Project Name: TOWNSITE OF WESTLAND

CITY OF ALBUQUERQUE  
PLANNING DEPARTMENT  
DECEMBER 29, 2004  
DRB Comments

APPLICATION # 04-01911

RE: Lot 22, Block 8, Original Townsite of Westland / Minor SPBP

A1	SITE PLAN
1"=20'-0"

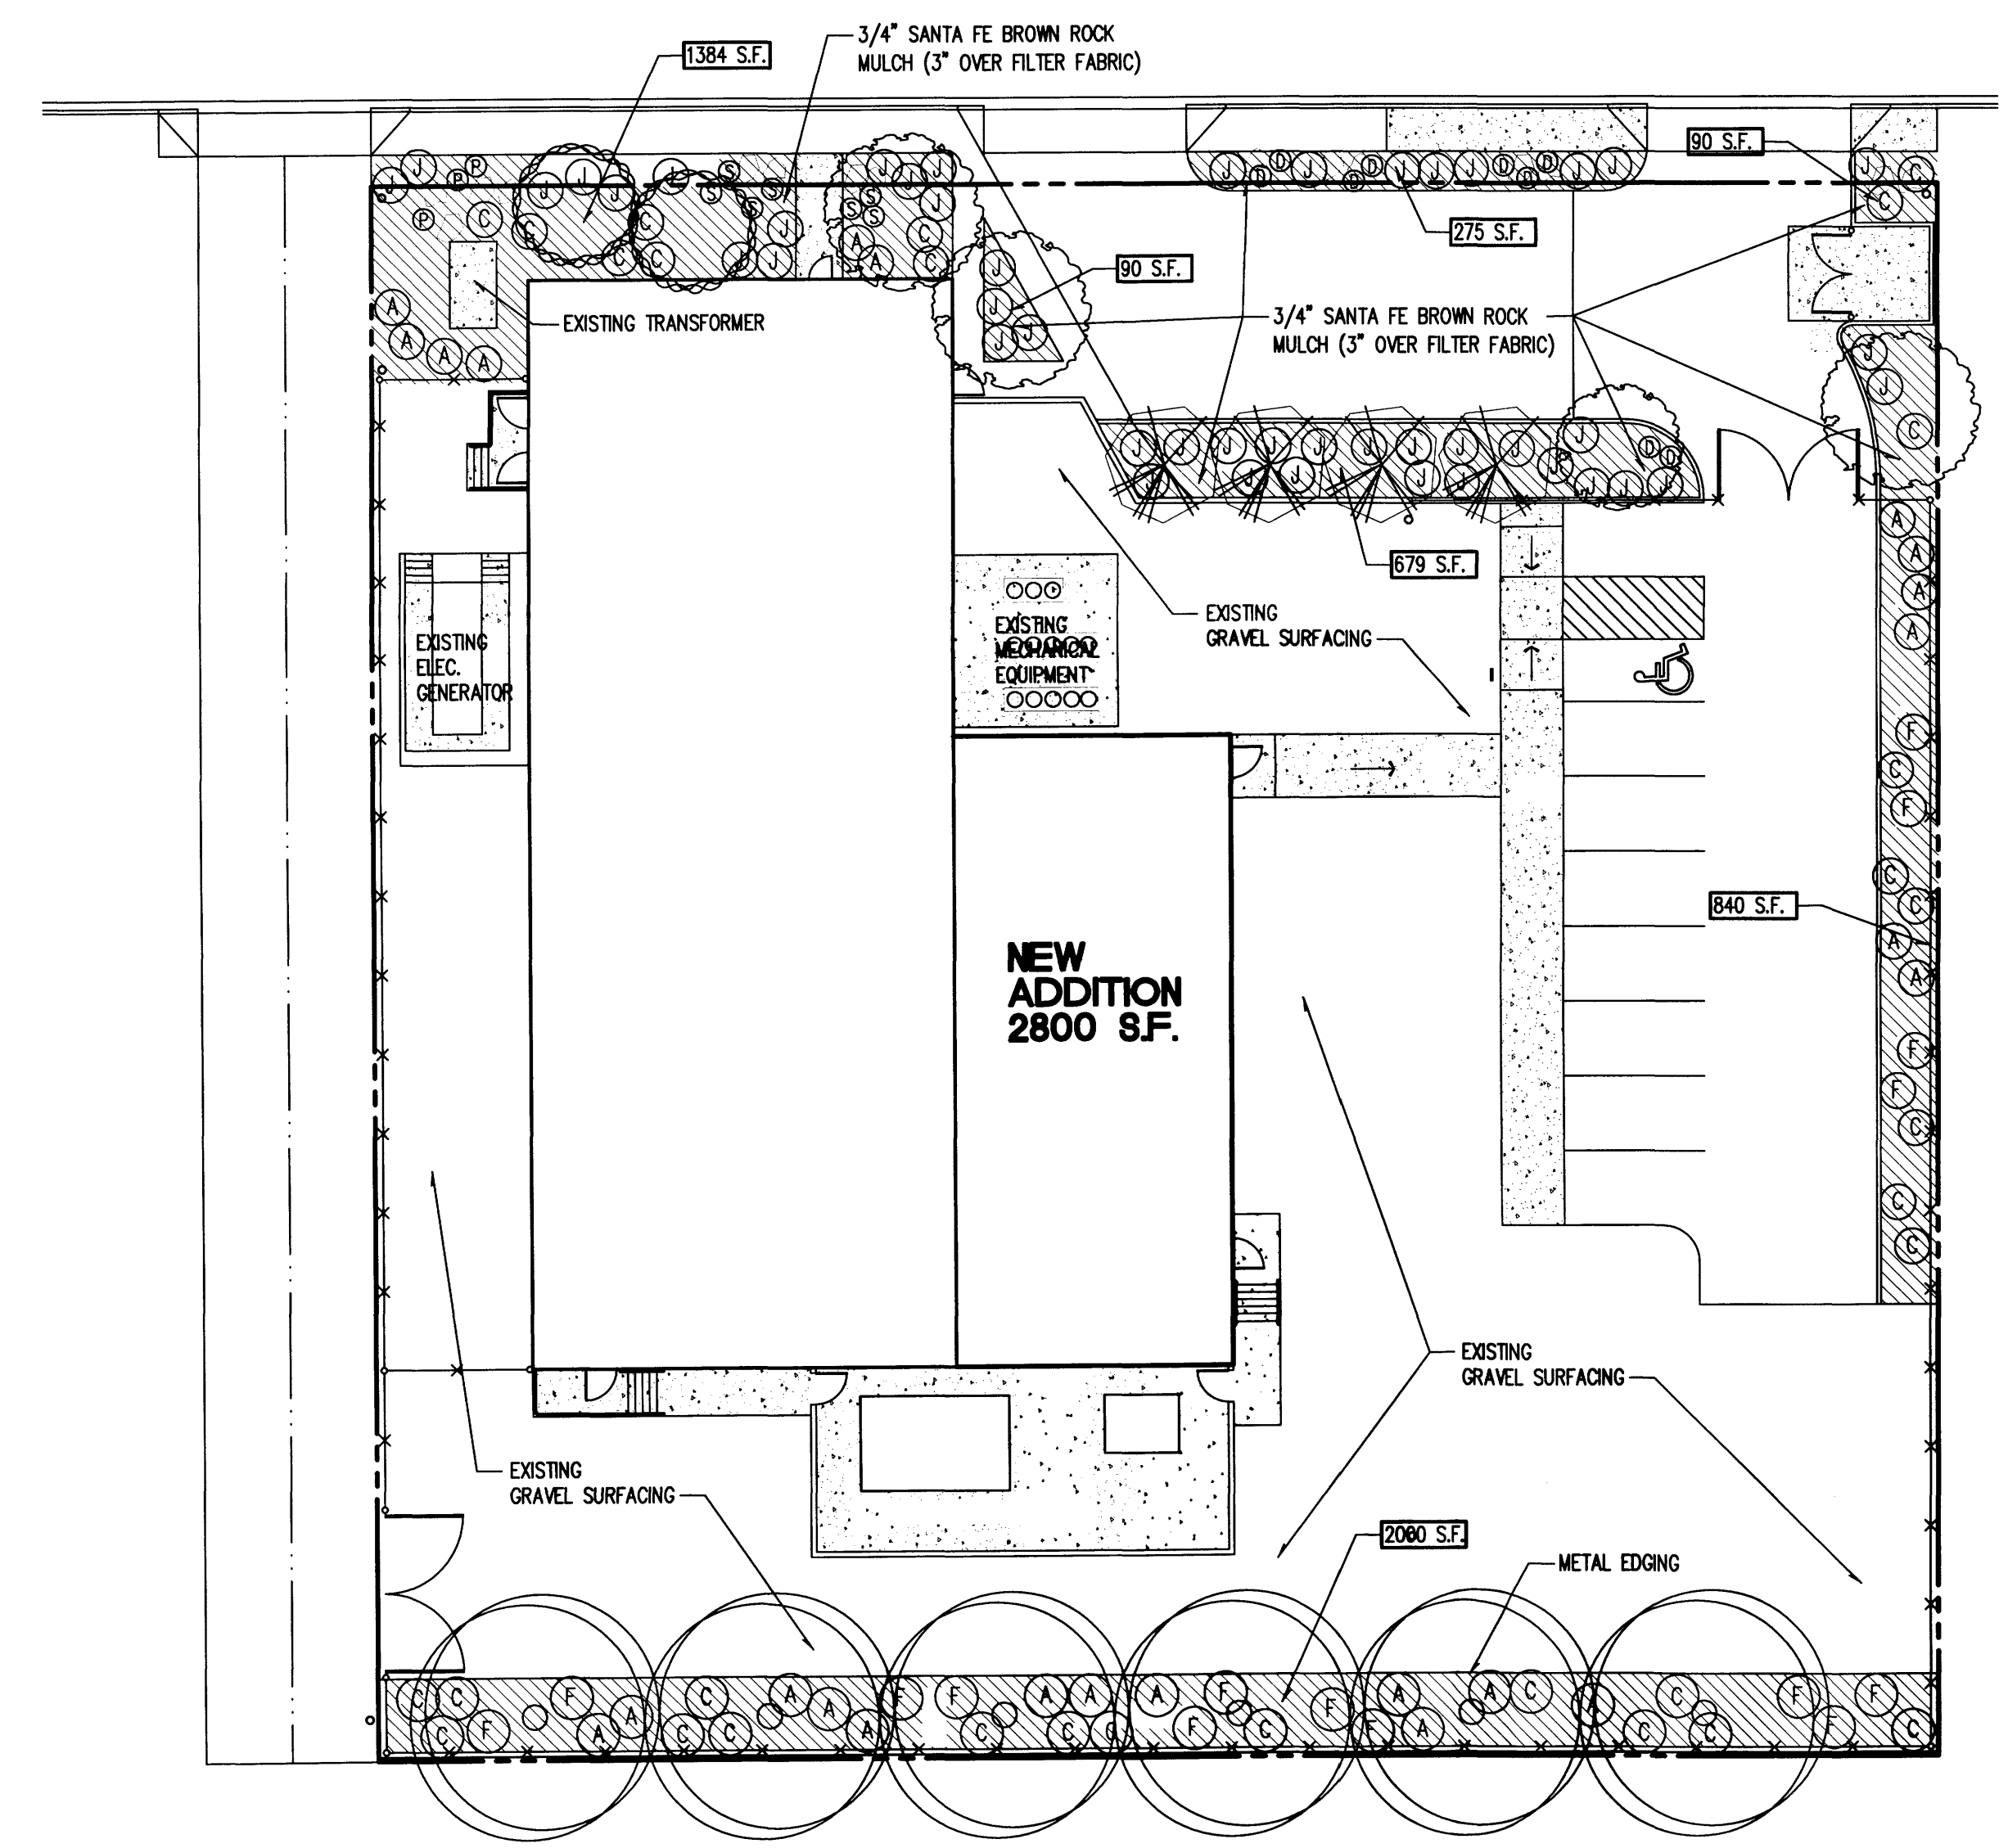
1. The Zoning on the Site Plan should be corrected to read SU-2/IP
2. Does existing chainlink fence have concertina wire on top? If so, it must be removed.
3. The site plan should indicate the square footage and location of the future addition in order to correctly calculate the landscape requirements.
4. The Landscape Plan indicates 1160 sf of fenced area, which is not included in the landscape calculations. This fenced area is not shown on the Landscape Plan and it is questionable whether this area can be subtracted from the net lot area according to Section 14-16-3-10 of the Zoning Code.
5. Need to distinguish between existing and proposed landscaping.
6. What color is the existing CMU? The Elevation Plan should indicate the color of the paint that will be used to match the existing paint.
